Your Ref: OWPC17972
Our Ref: AB/24/18/HH
Please ask for:
Mrs A Gardner

23rd April 2018

Retention of playhouse climbing frame in rear garden.
41 Fitzalan Road Arundel

PROPOSED ROOF PLAN, LOCATION & BLOCK

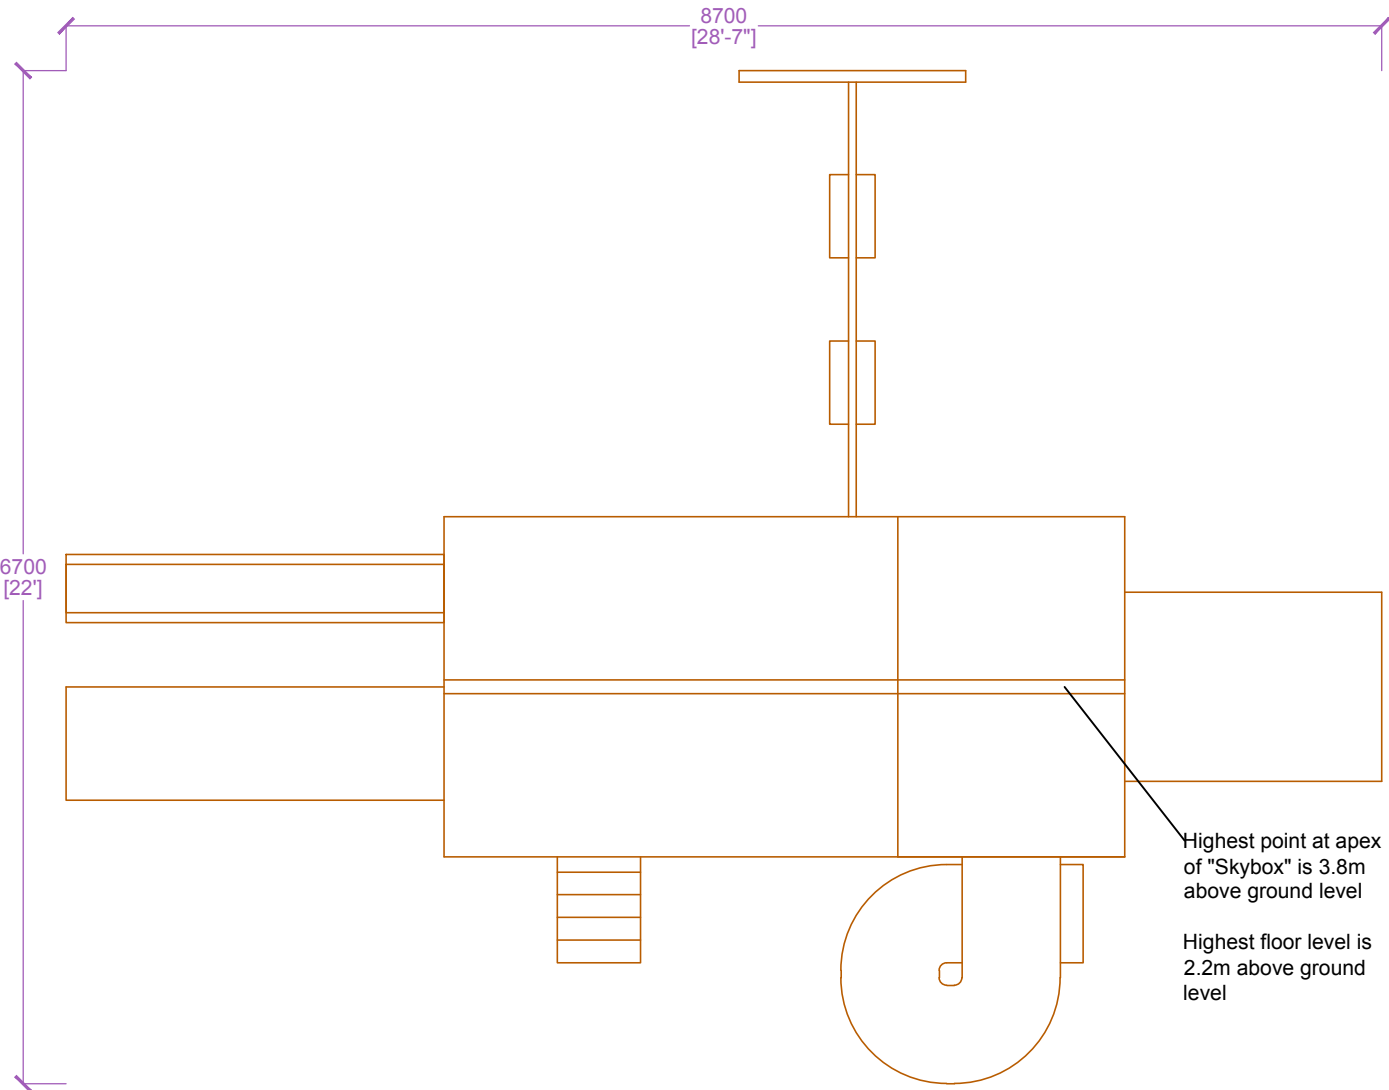
The Committee objected on the grounds that the scale and size of the development was excessively large and unduly prominent for this rear garden location and would result in a loss of privacy to adjoining occupiers and diminish the standard of their residential amenity to an unacceptable extent.
